PORTLAND MAINE

July 21, 2011

RE: 85 Machigonne St, cor. of Barry & Brookline Dr.- 192-B-3, 4, 7, 8 – R-3 Zone

Boundary Survey & Site Plan
Made For
Steven & Donna Williams
85 Machigonne Street, Portland, Maine

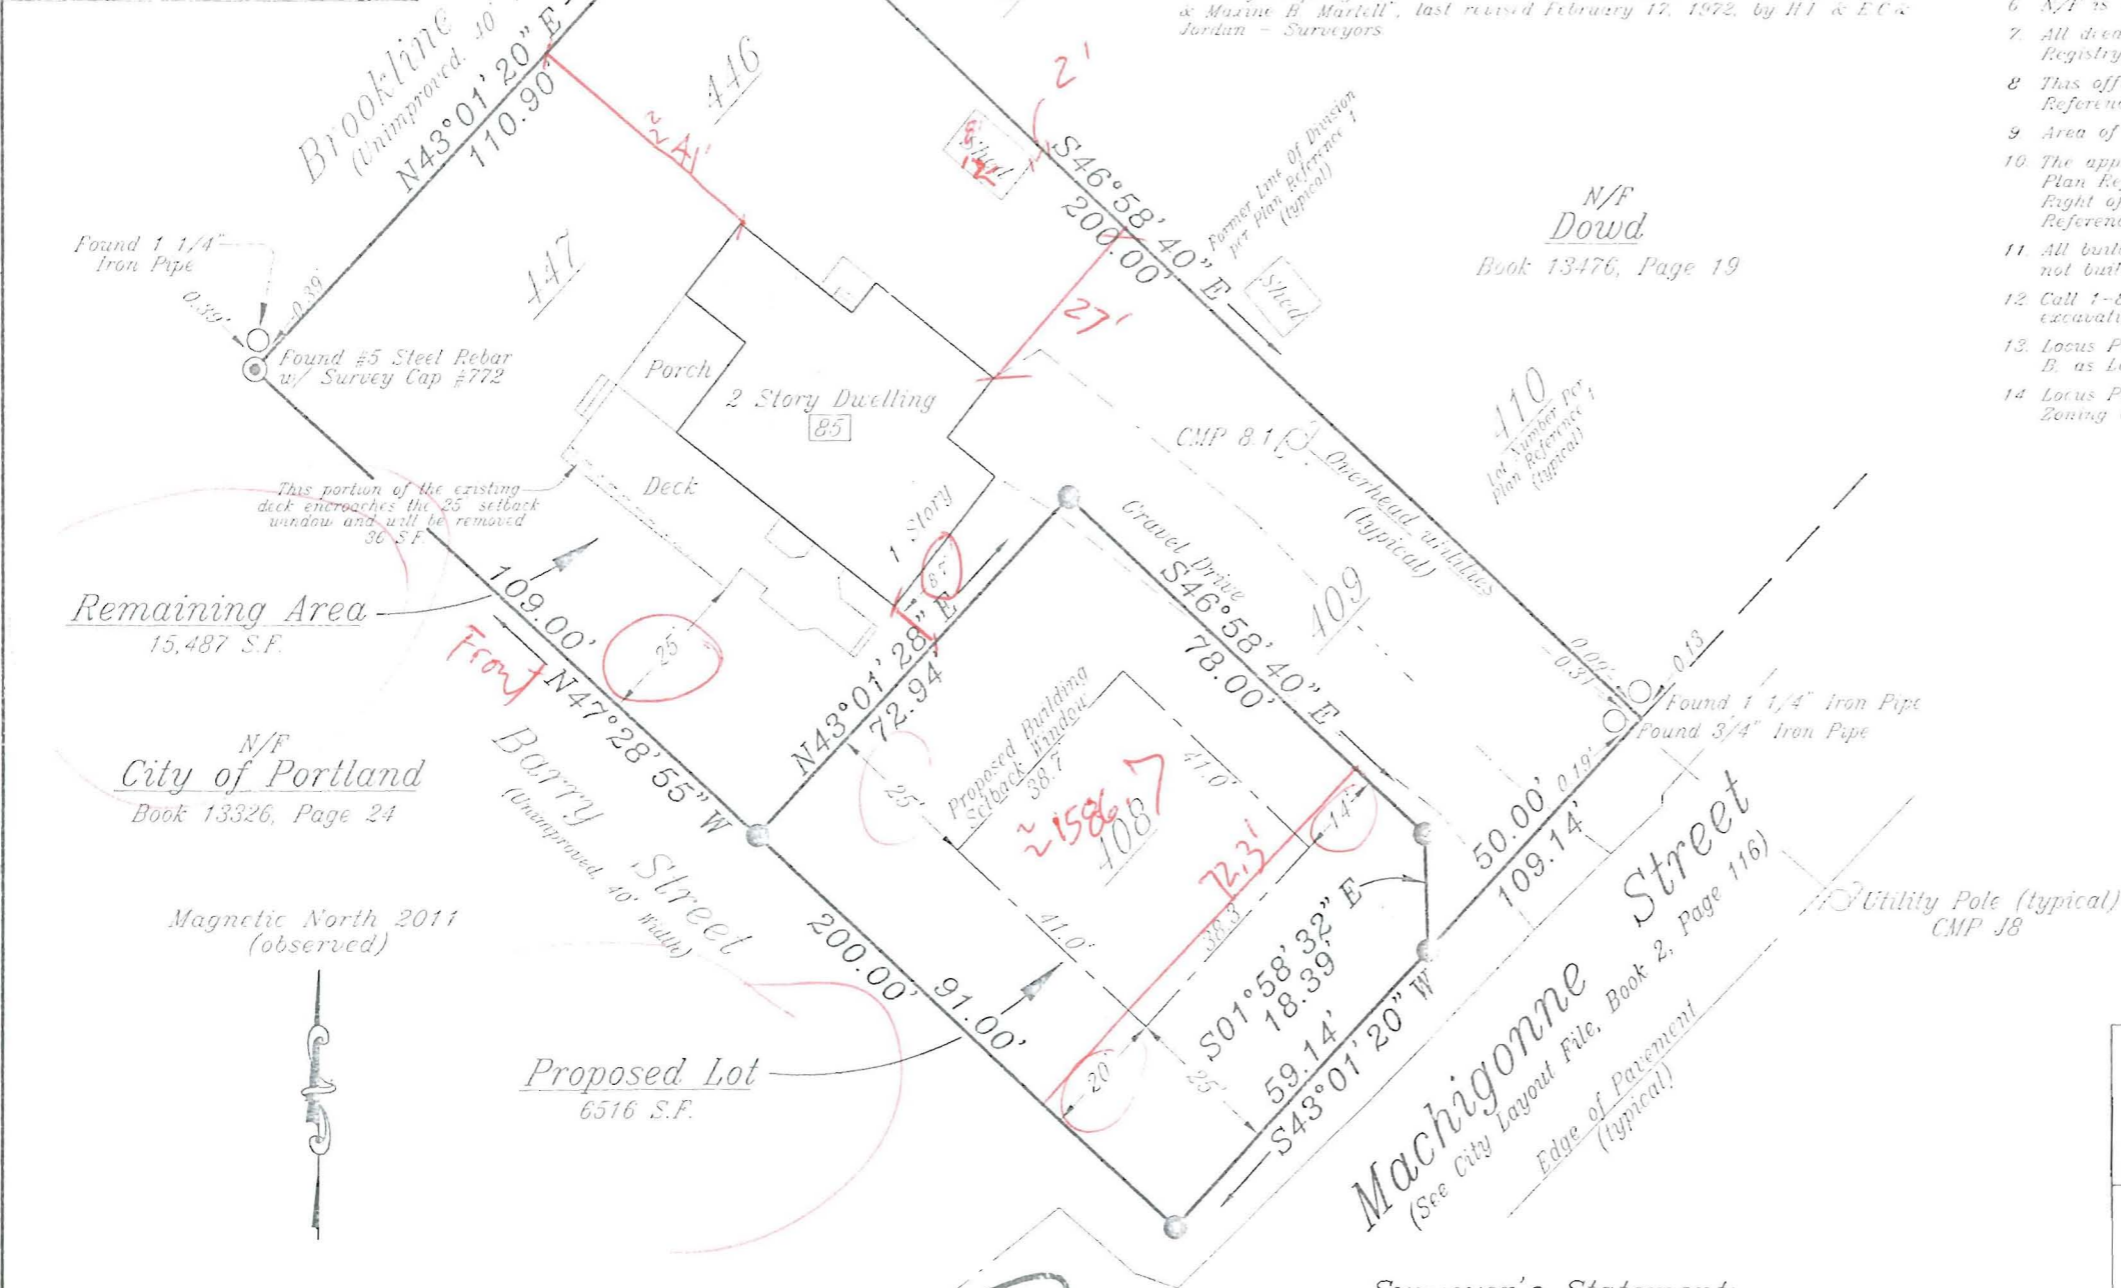
It is understood that the lot containing the existing house will be re-orientated so that the front of the lot faces Barry Street with the official street access from Machigonne Street remaining. This re-orientation of the lot will necessitate the removal of a portion of the front deck in order to comply with the required front setback of 25 feet. All other dimensional requirements of the lot containing the existing house are meeting the R-3 residential zone requirements, including, but not limited to, lot width, lot coverage, and all required setbacks.

Please note that the shed denoted on the survey has no history of permits in our records and does not meet current R-3 zone setbacks. A detached shed that is 144 square feet or less requires a side and rear setback of no less than 5 feet. There should be a permit taken out to legalize the shed and to move it the necessary amount in order to meet the current setbacks.

It is also cautioned that this division of land shall not precede the removal of the amount of deck that is needed to allow the owner to use Barry Street as a front yard. If you have any questions regarding this matter, please do not hesitate to contact me at (207) 874-8695.
